**Reference: 84 & 100 Gloucester Street: Site Plan Application  
Response to Comments (1<sup>st</sup> Round)  
City File Nos.: D02-02-23-0013 and D07-12-23-0021  
Our File No.: 122173**

On behalf of our clients Claridge Homes, Novatech is in receipt of the City's comments with respect to the Site Plan Control Application No. D02-02-23-0013 and D07-12-23-0021 dated May 29, 2023. The following comments and responses shown in **BOLD** below are with respect to the Transportation Impact Assessment which was submitted January 11, 2023.

DRAWING TITLE: PARKING FLOOR PLANS

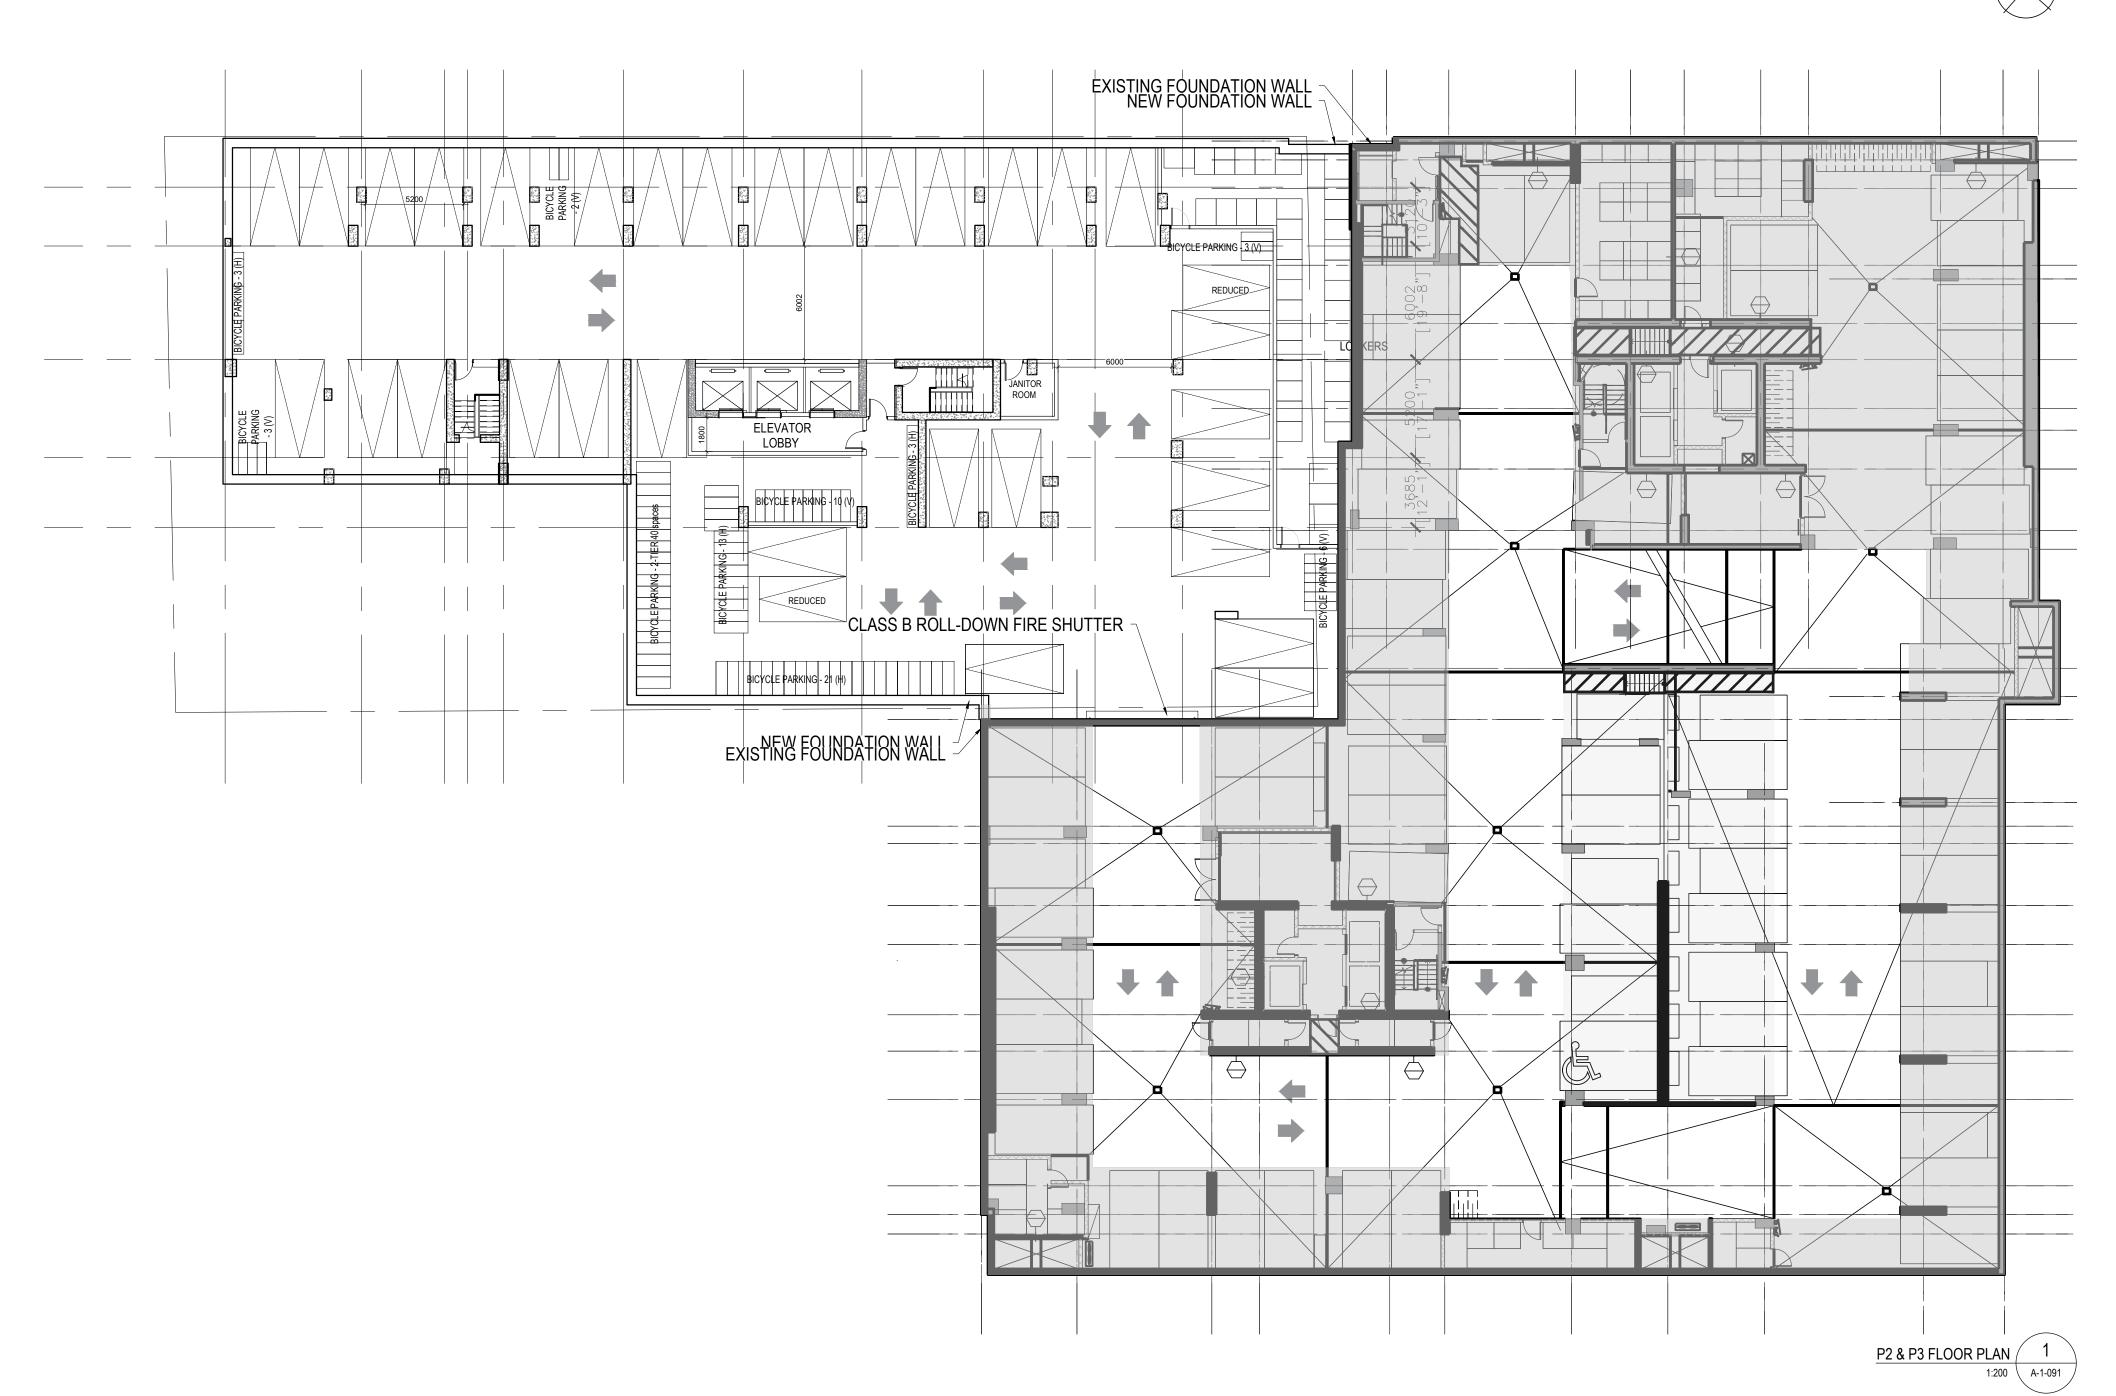
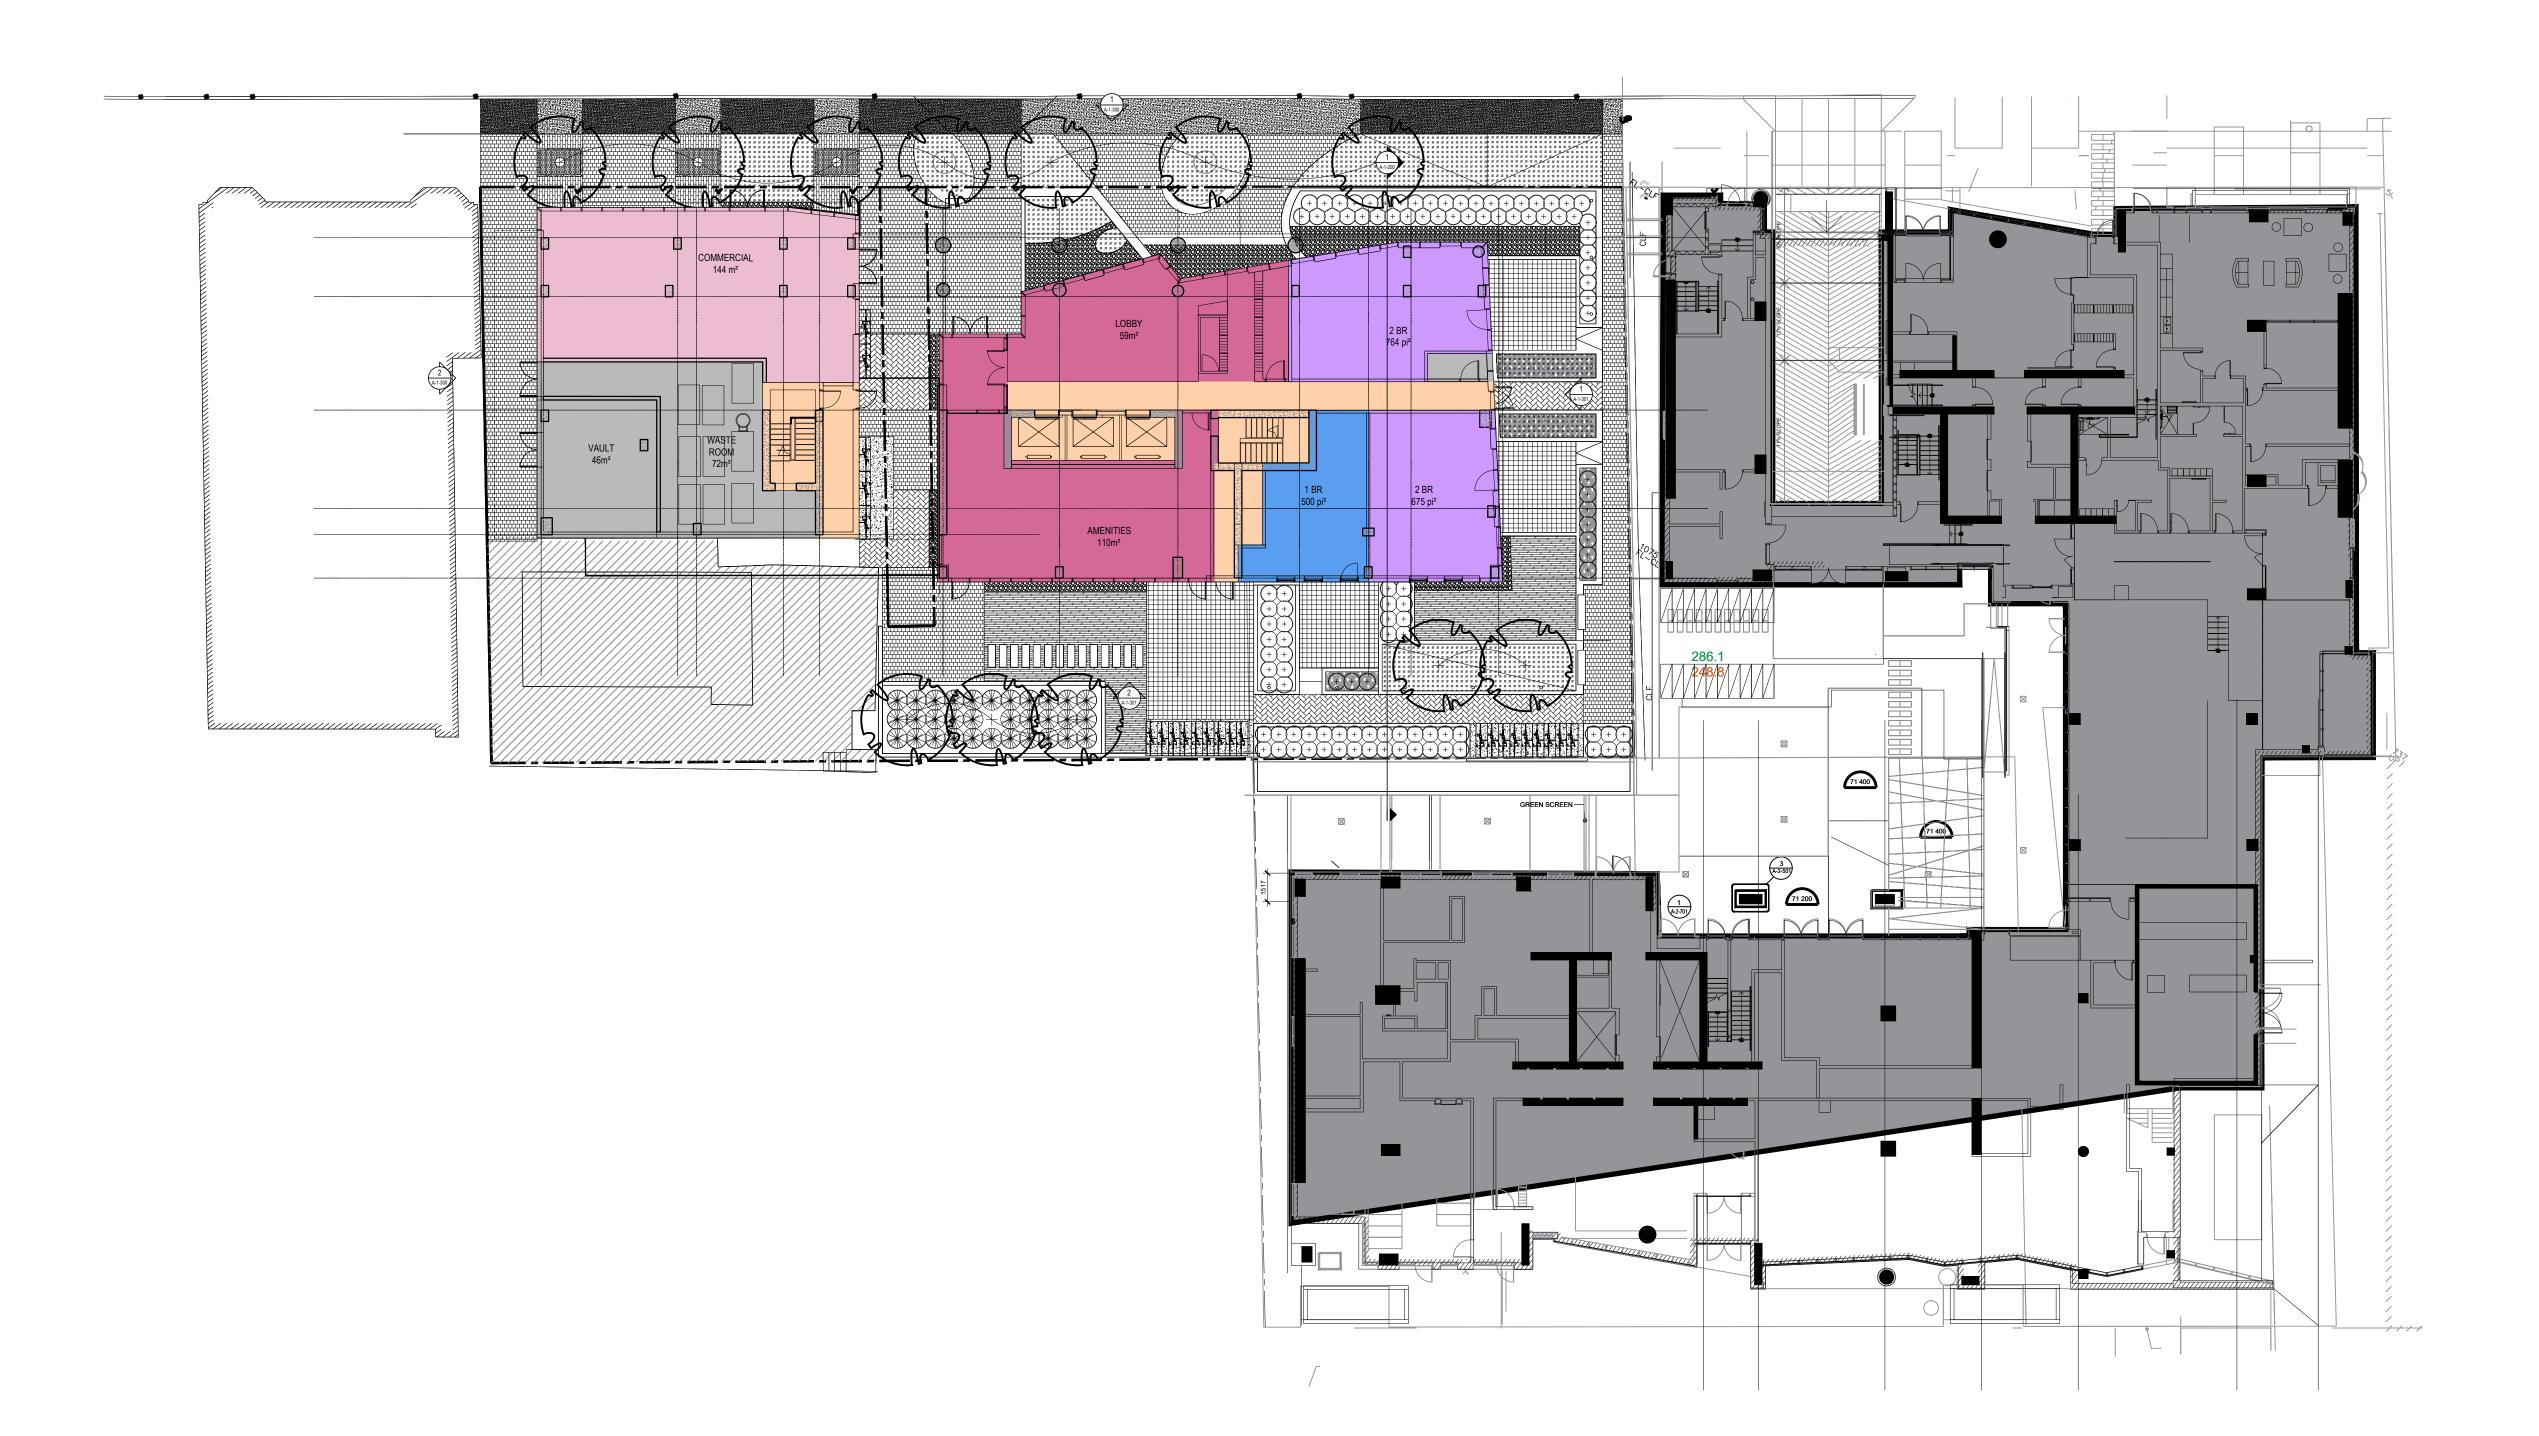
5.16. The TIA states that "a total of 165 bicycle parking spaces will be provided within the parking garage". The Application Summary states that the development includes "315 enclosed bicycle parking spaces". From the site plan and parking floor plans (dated 2022-12-16), approximately 230 bicycle parking spaces were counted in levels P1-P3, while 18 bicycle parking spaces were counted on the exterior of the building. For consistency, revise all submission materials to report the same number bicycle parking provided. A secure bicycle parking supply of 1 space per unit is preferred.

**Acknowledged, this has been updated in the revised TIA report.**

GROUND FLOOR PLAN 1
1:200 A200

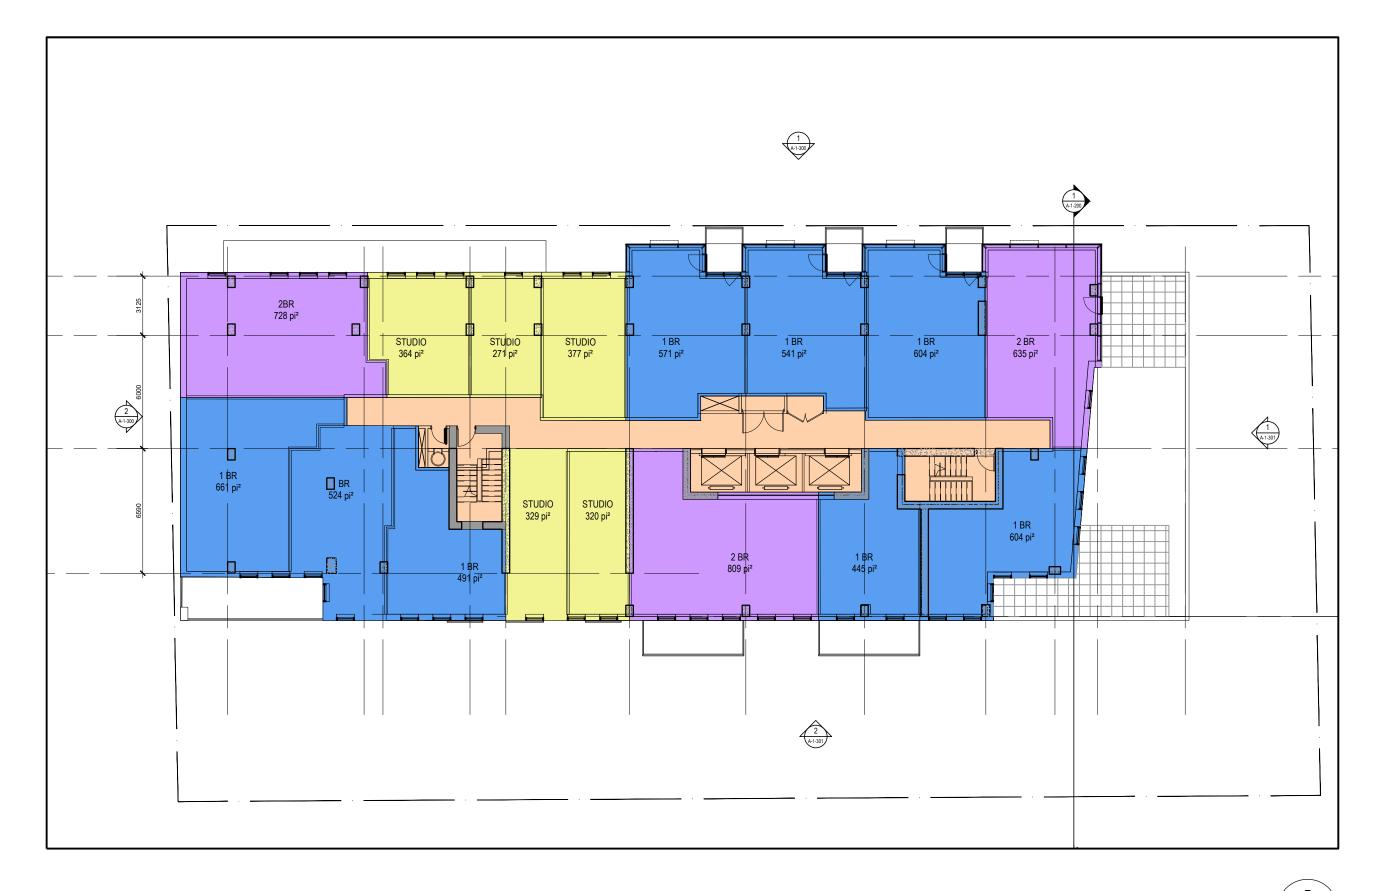
5.19. The site plan shows pavers within the 2.0m-wide sidewalk in front of the commercial use. The 2.0m-wide sidewalk should be concrete. Pavers in the clear sidewalk width are not recommended.

**Pavers have been removed from the sidewalk and replaced with coloured concrete.**
